# CITY OF ALBUQUERQUE

**Re: Arroyo Vista Apartments, 11030**  
**Request for Certificate of Occupancy**  
**Transportation Development Final Inspection**  
Engineer's/Architect's Stamp dated 11-04-16 (G16-D153)  
Certification dated 05-21-18

Based upon the information provided in your submittal received 05-22-18,  
Transportation Development cannot approve the release of Certificate of Occupancy  
for the above referenced project.

TCLI

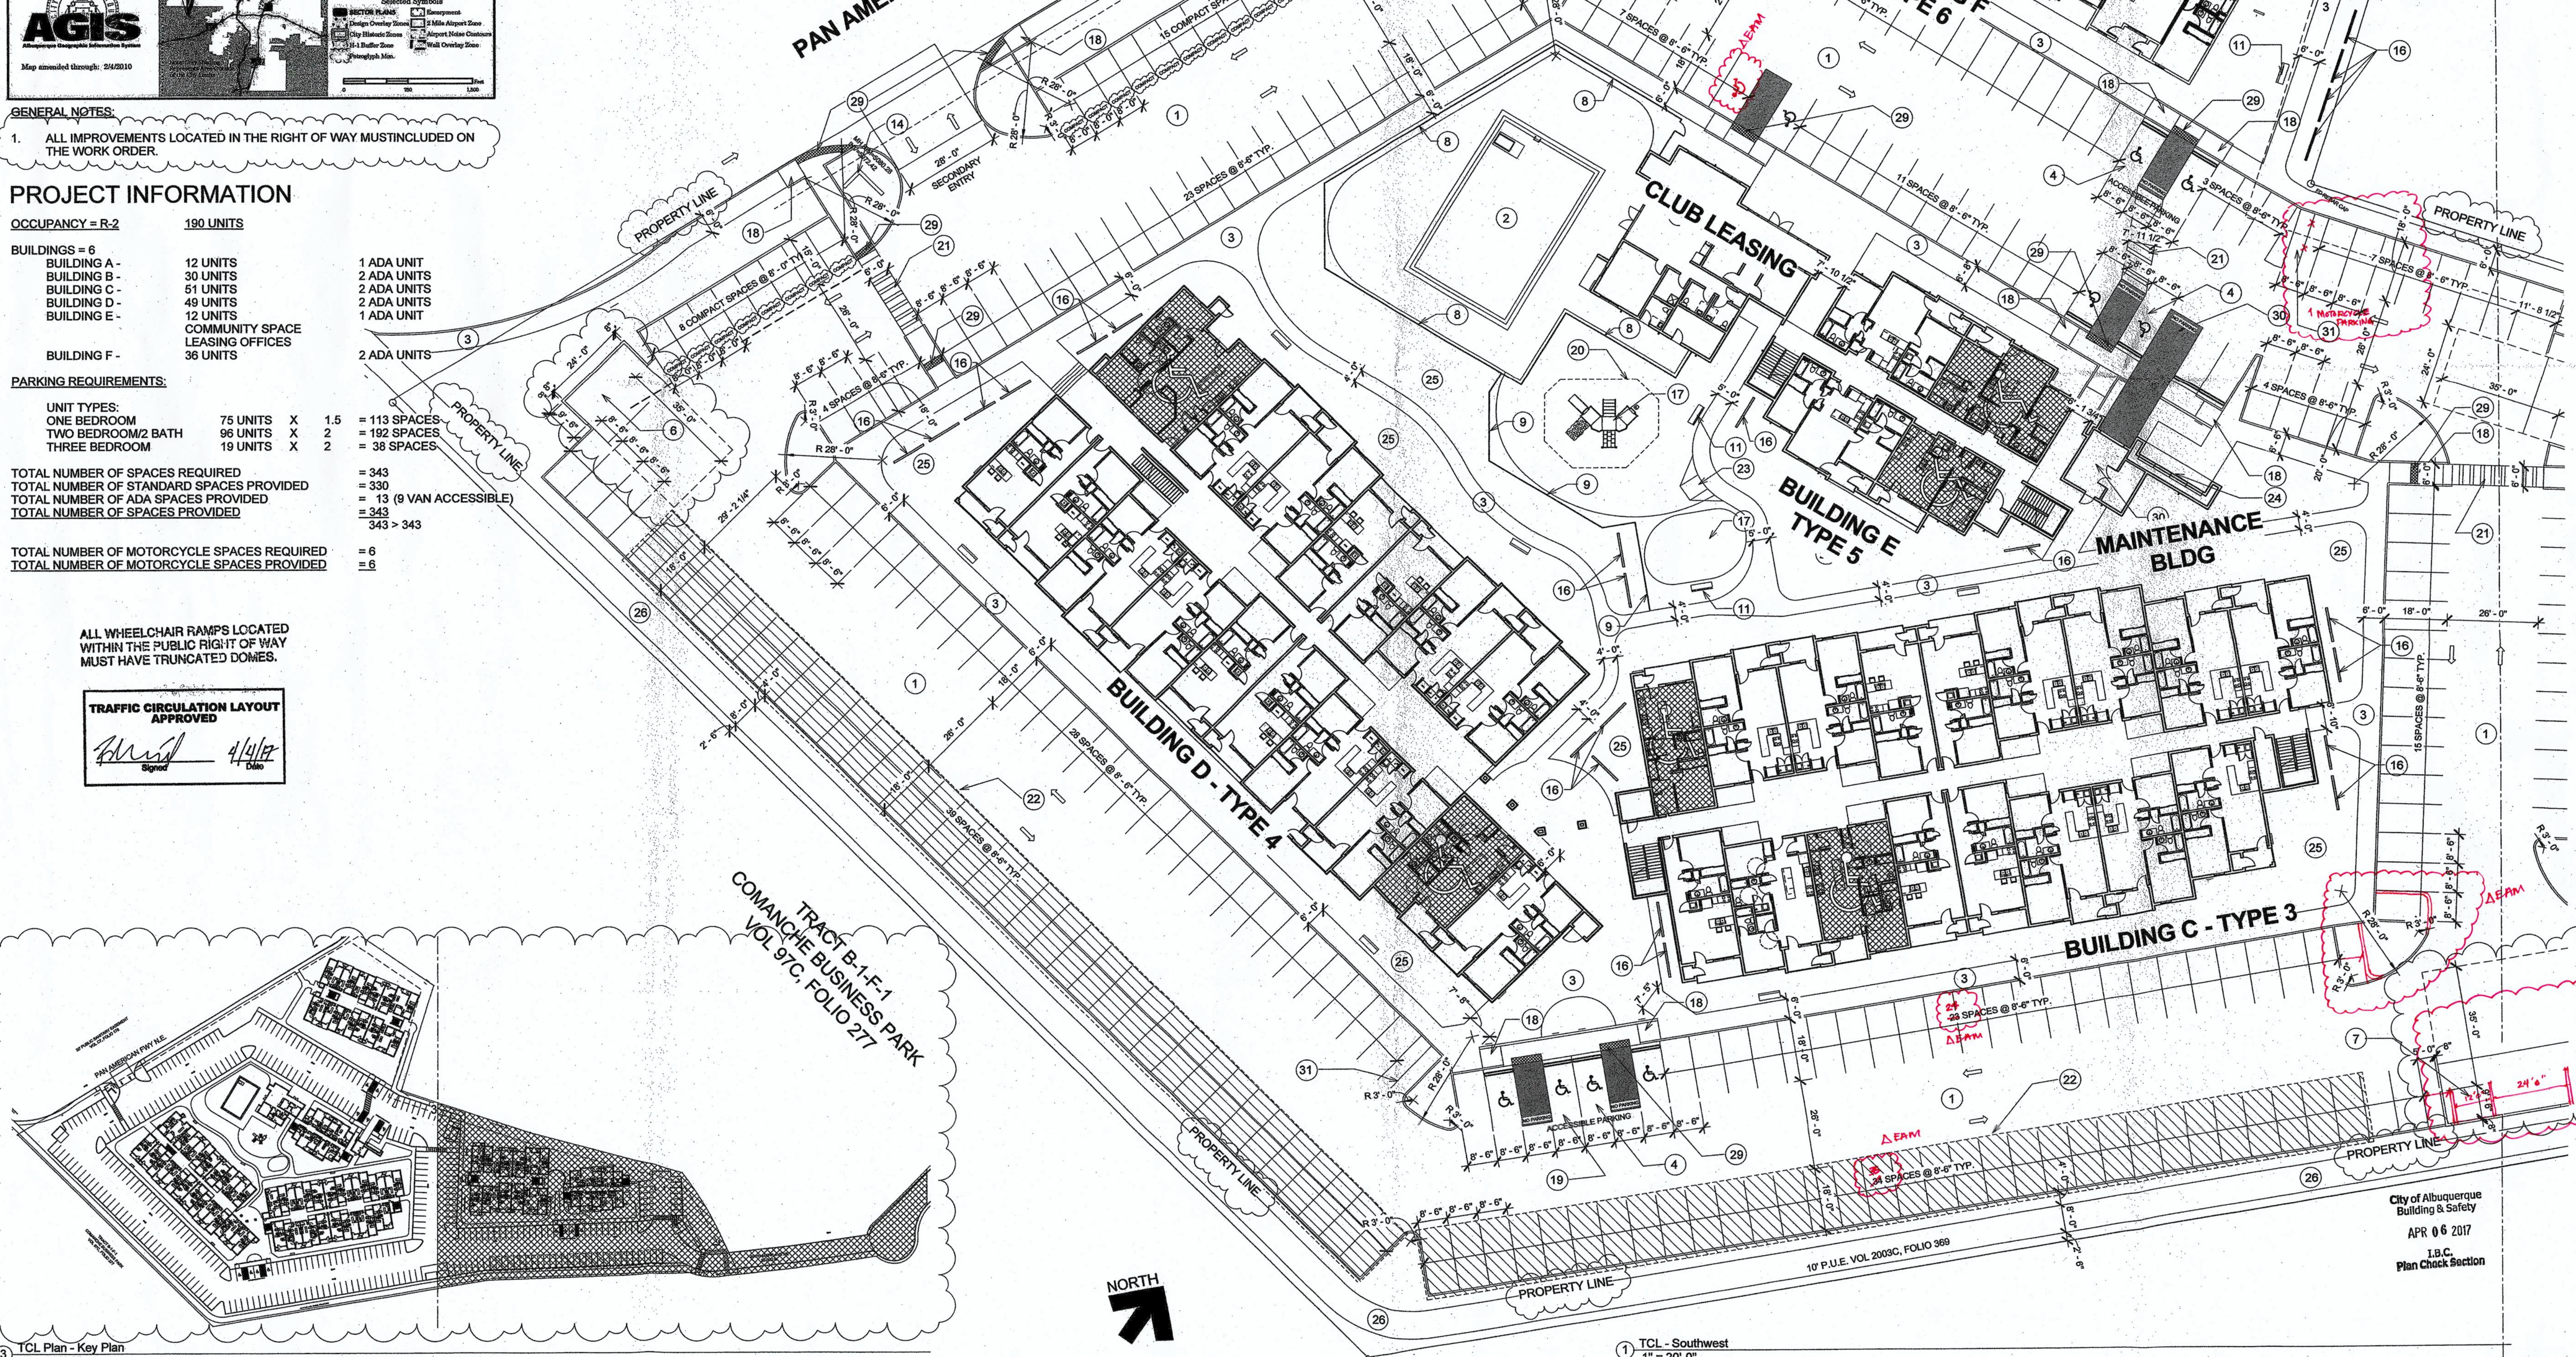
1. Motorcycle parking spaces shall be designated by its own conspicuously posted upright sign, either free-standing or wall mounted per the zoning code. Plan called out 2 motorcycle spaces site had 1.
2. Please add bike anchored bike racks per approved plan.
3. Please make sure no contractor vehicles are parked along Bryn Mawr Dr. NE.
